Reference No:	2025/62/92598/E
Site Address:	Co Op Academy Smithies Moor, Leeds Old Road, Heckmondwike, WF16 9BB
Description:	Redevelopment of school, including demolition of existing buildings and erection of replacement single storey school building with external works including provision of a forest school, hard and soft PE and play spaces, car and cycle parking, bin store, sub-station, pedestrian, vehicle access, and landscaping
Recommending Officer:	Katie Chew

Officer Report

Proposal: Redevelopment of school, including demolition of existing buildings and erection of replacement single storey school building with external works including provision of a forest school, hard and soft PE and play spaces, car and cycle parking, bin store, sub-station, pedestrian, vehicle access, and landscaping.

03 - Roof_GA Plan - Planning - 1 of 2

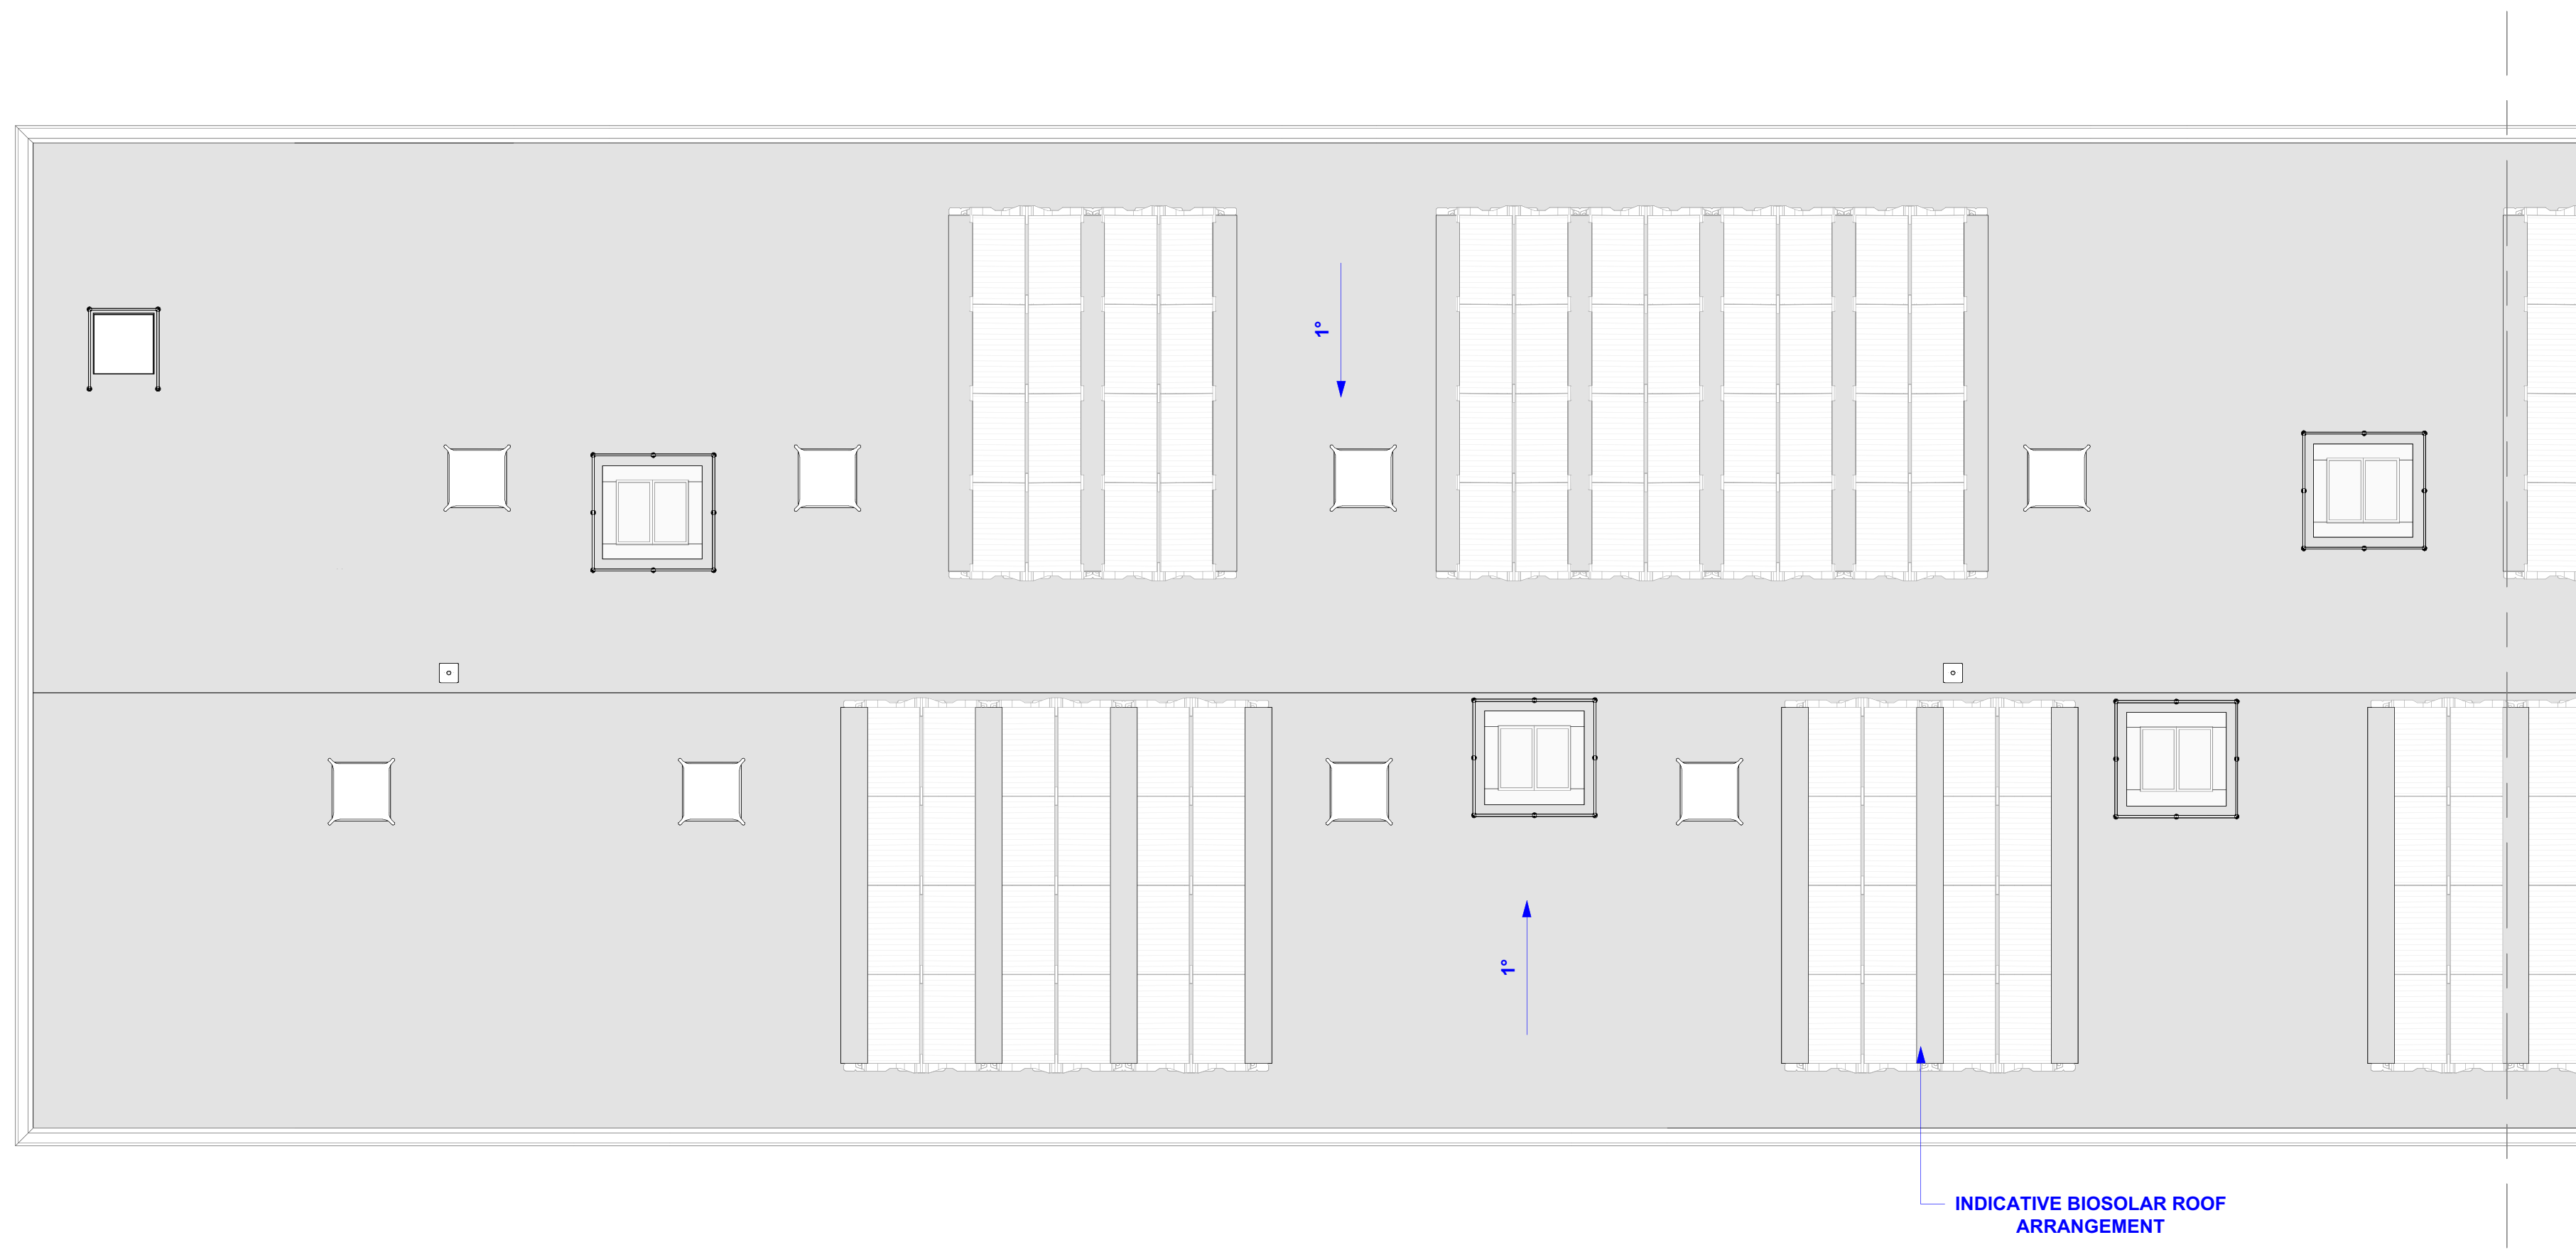
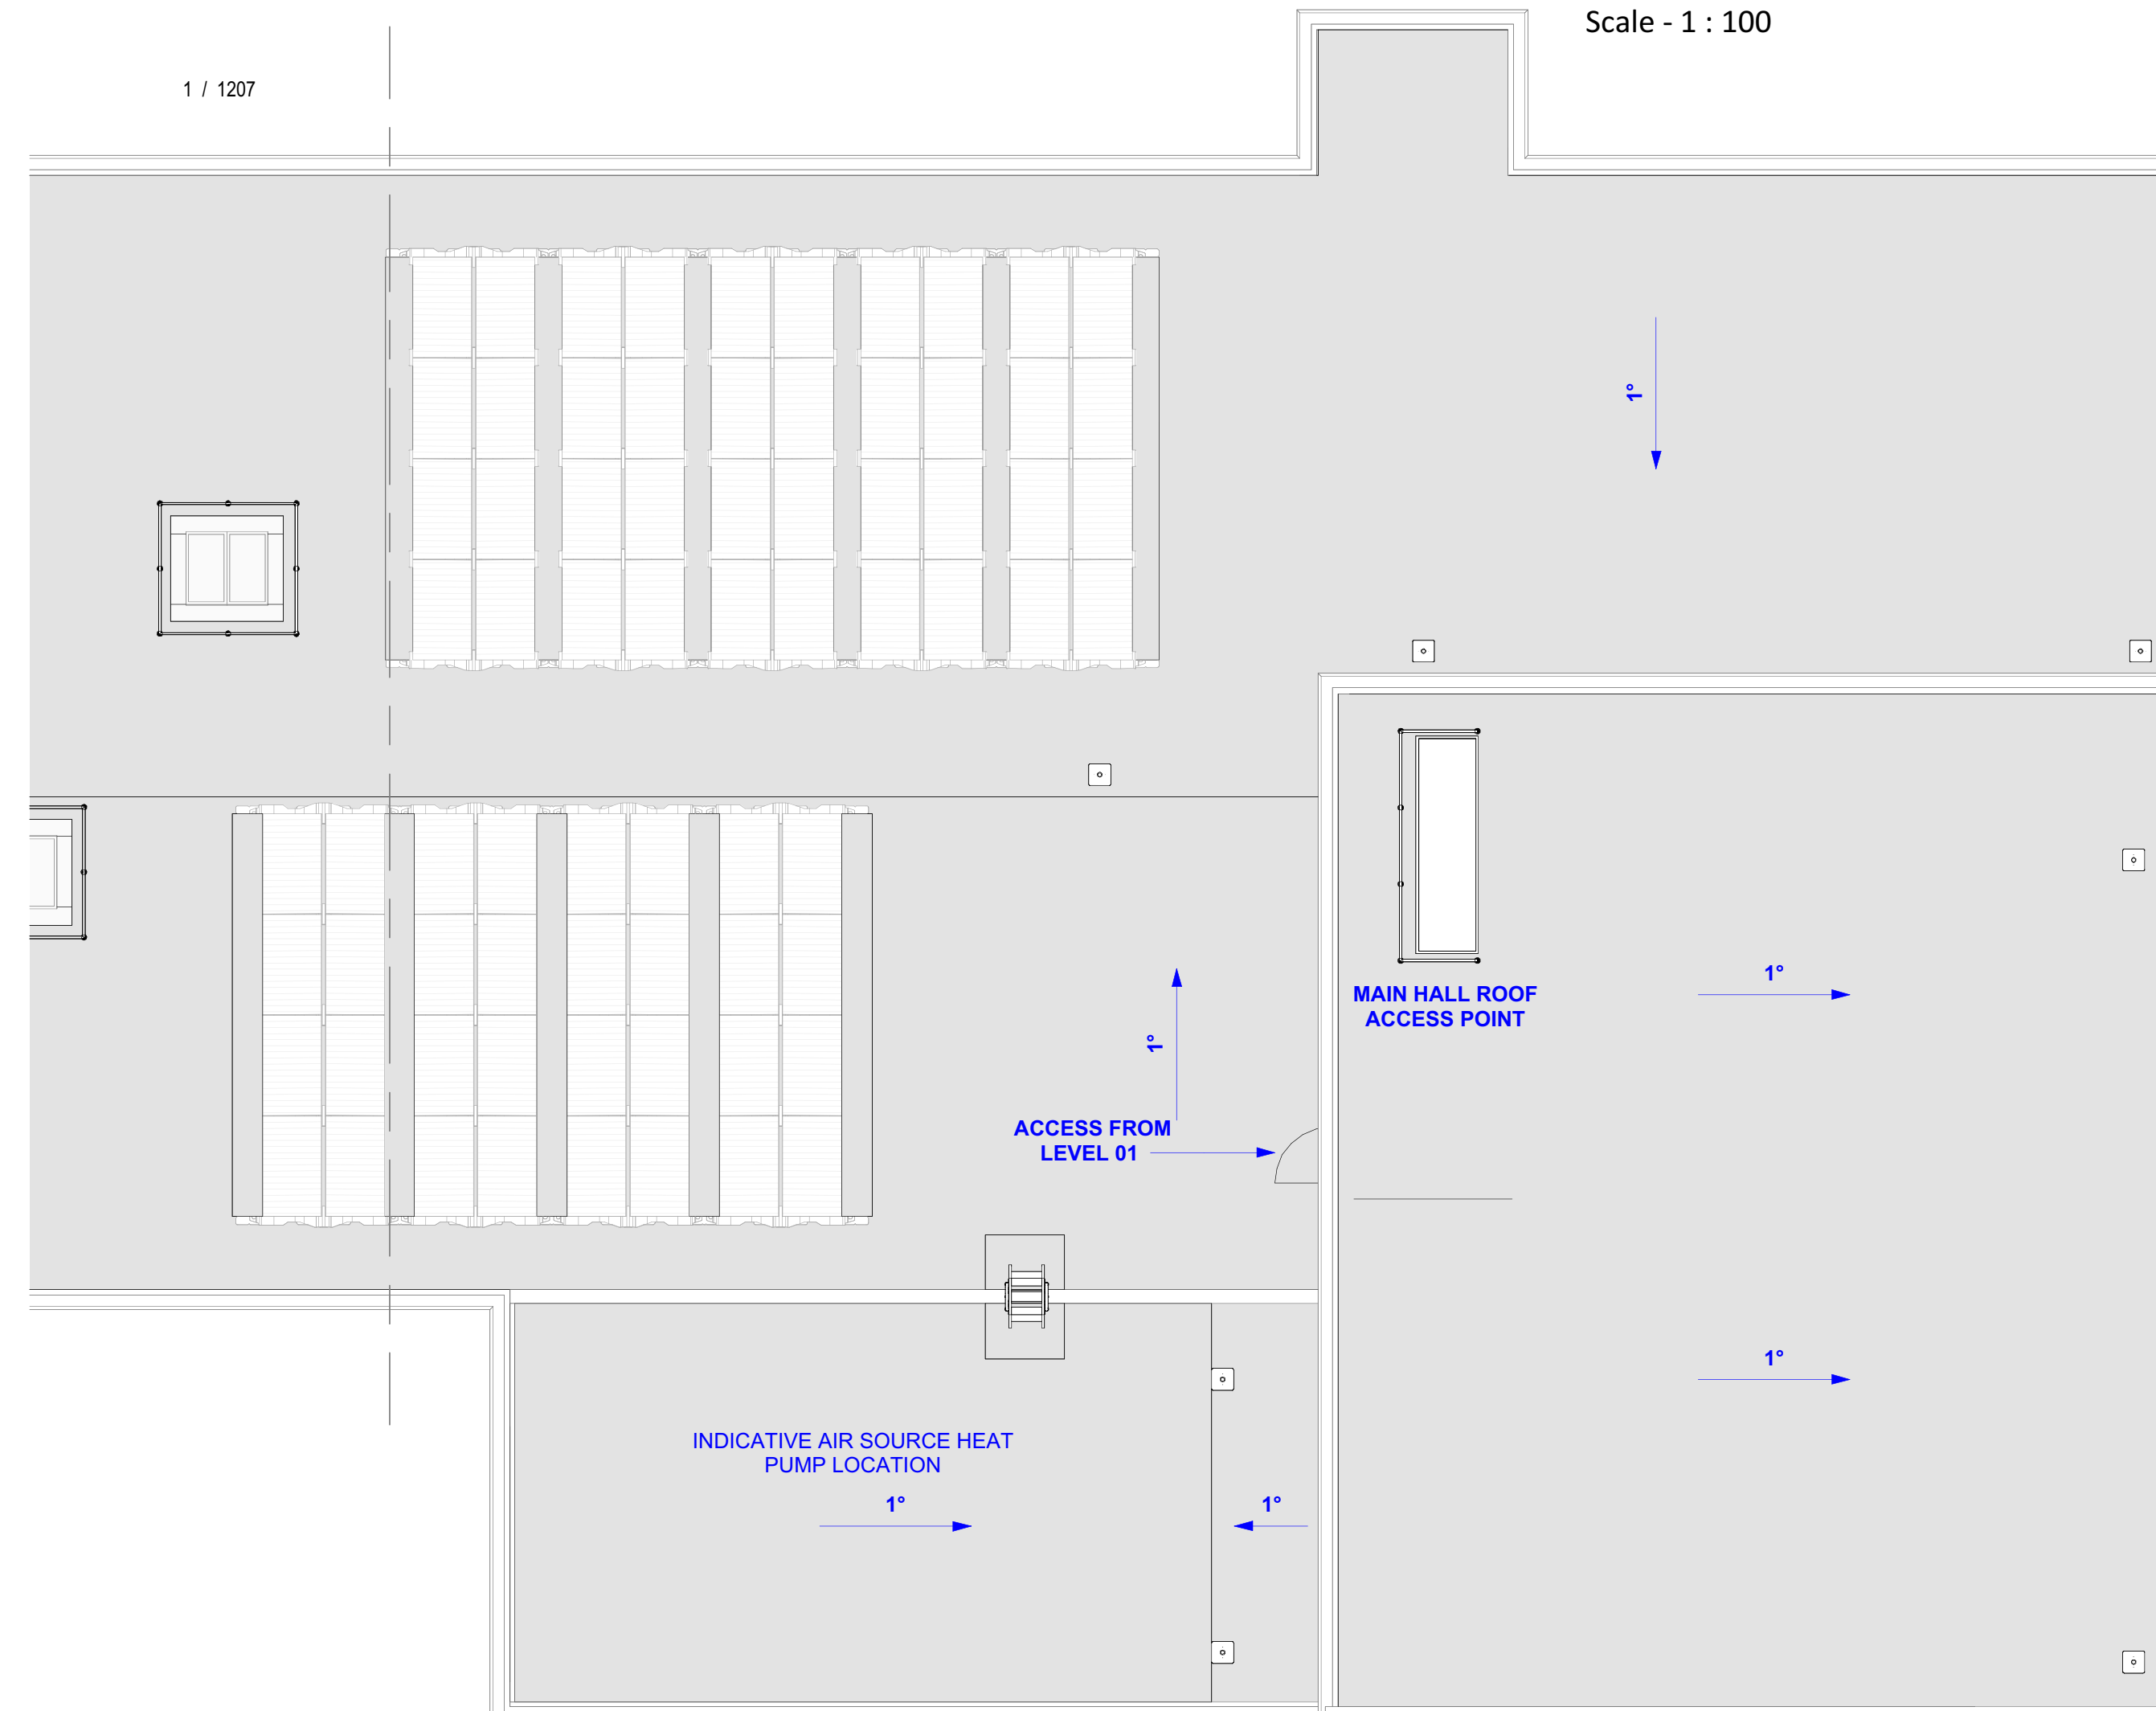
- The plans indicate a gas heating boiler – why not air or ground source heat pumps. It is not clear if solar panels are to be included, but the roof offers plenty of space to do so.

Officer note: Noted. The proposals do include an Air Source Heat Pump and Biosolar roof arrangements, as shown within the submitted proposed roof plan.
